The Planning Inspectorate
Yr Arolygiaeth Gynllunio

Acceptance of Applications Checklist

North Lincolnshire Green Energy Park - Section 55 Acceptance of Applications Checklist

Title Designated and Non-designated Heritage Assets Within 1km of the Order Limits

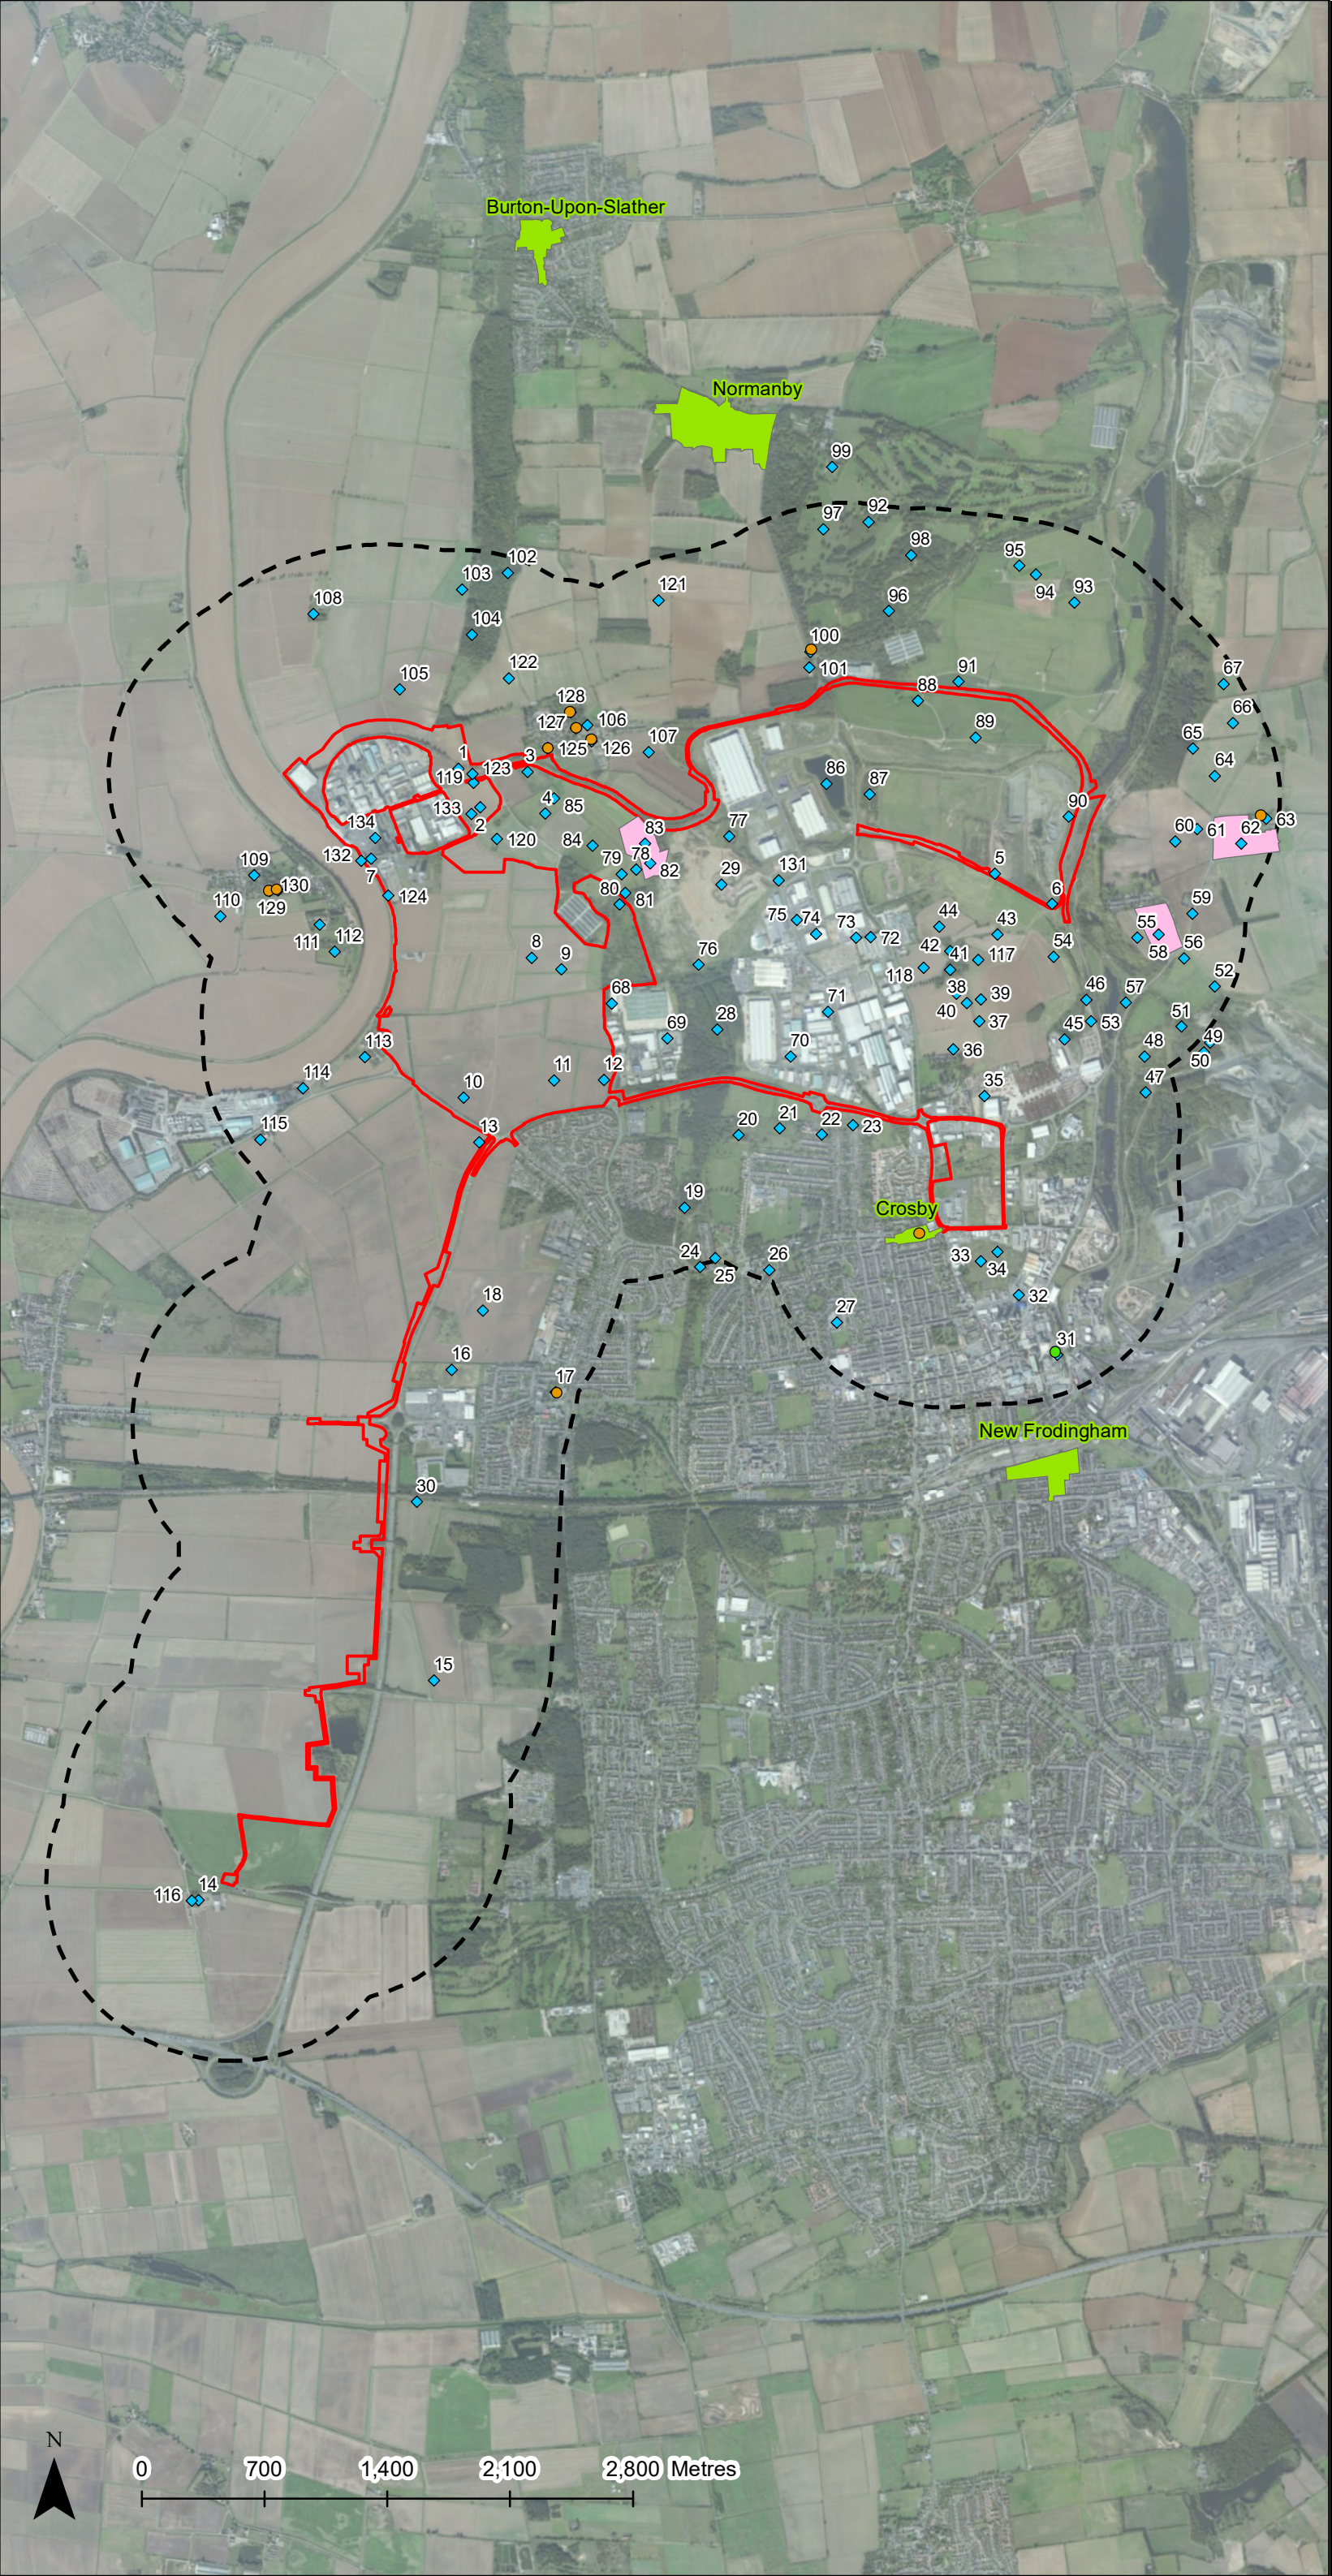
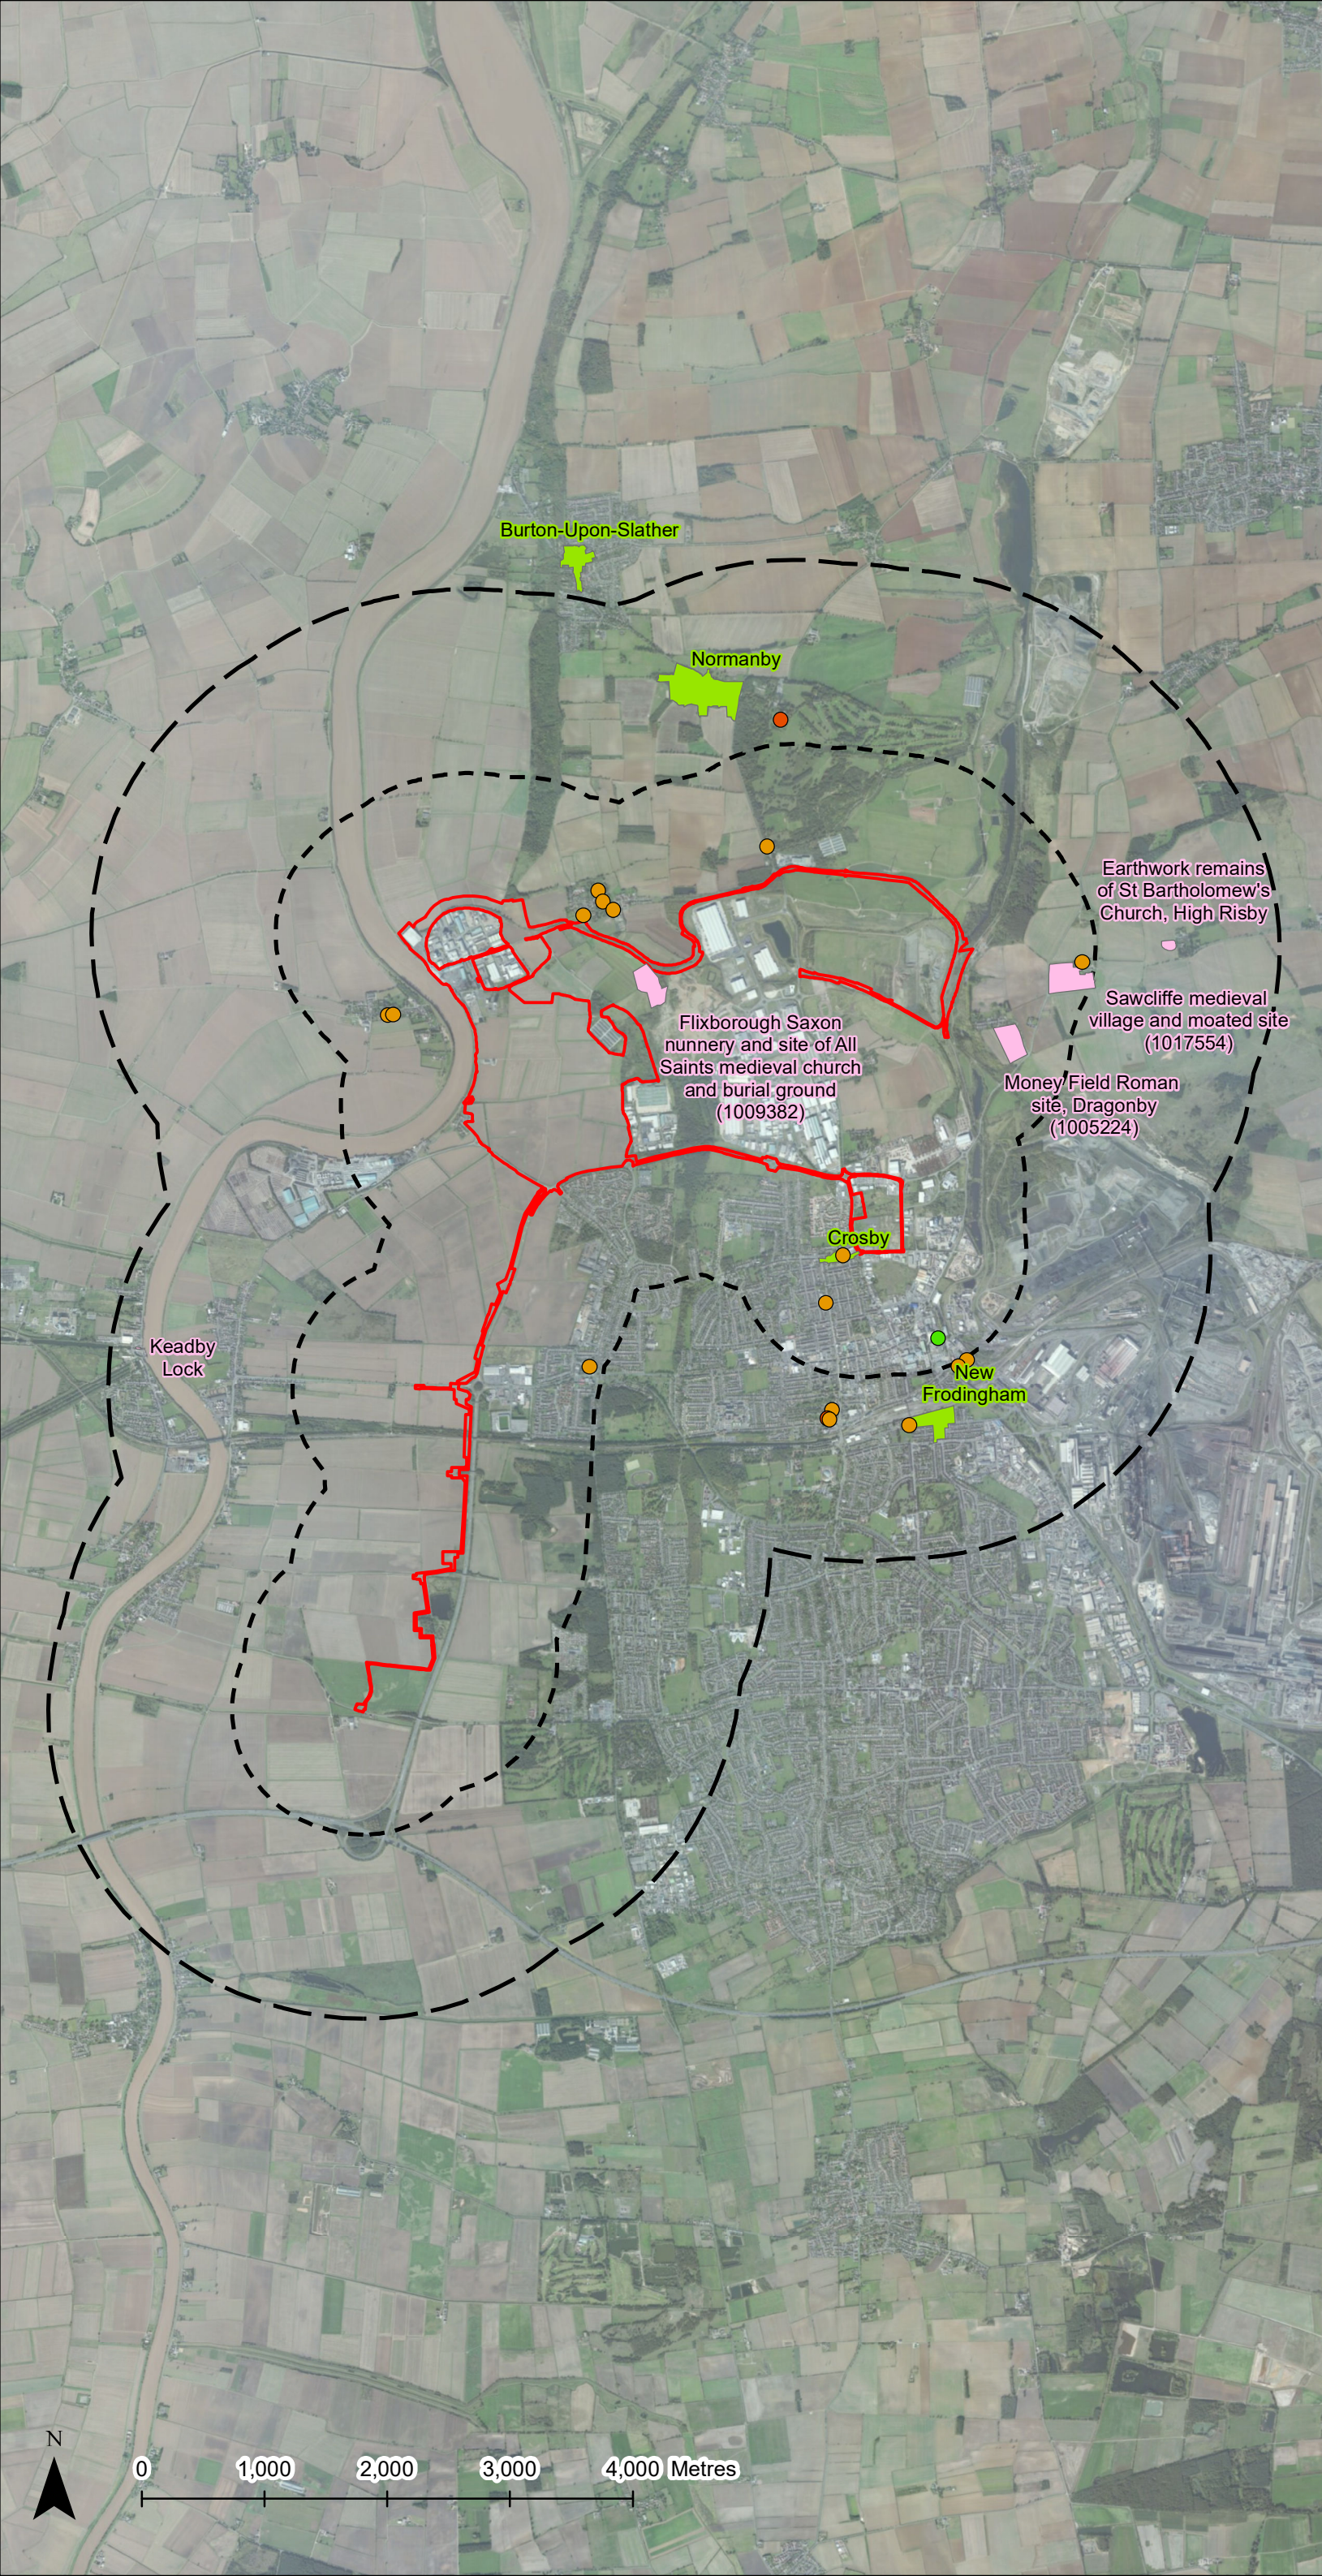
Are they of a satisfactory standard?	Yes		Are they of a satisfactory standard?	Yes
30	Are there any observations in respect of the documents provided at Box 29 (a) to (q) above?				
<p><u>Plans showing statutory or non-statutory historic or scheduled monument sites or features of the historic environment (Document 4.7)</u></p>					
<p>The plans do not show the Grade II listed building (Angel of War Memorial) which ES Chapter 12 (Document 6.2.12) states is located within the study area. The plans also incorrectly labels some designated heritage assets as non-designated heritage assets.</p>					
<p><u>ES Chapter 12 (Document 6.2.12)</u></p>					
<p>Figure 1a of Appendix A to ES Chapter 12 replicates information shown in Document 4.7 and therefore has the same inconsistencies as highlighted above.</p>					
<p><u>ES Chapter 11 Landscape and Visual Impact (Document 6.2.11)</u></p>					
<p>ES Chapter 11 Landscape and Visual Impact includes longer distance viewpoints, as described in Table 17. Other than Viewpoint 11, which was selected as representative of users of the local public right of way network and is located at the Scheduled Ancient Monument of Flixborough Saxon Nunnery, it is not stated whether any of the viewpoints were selected to inform the assessment of heritage setting impacts.</p>
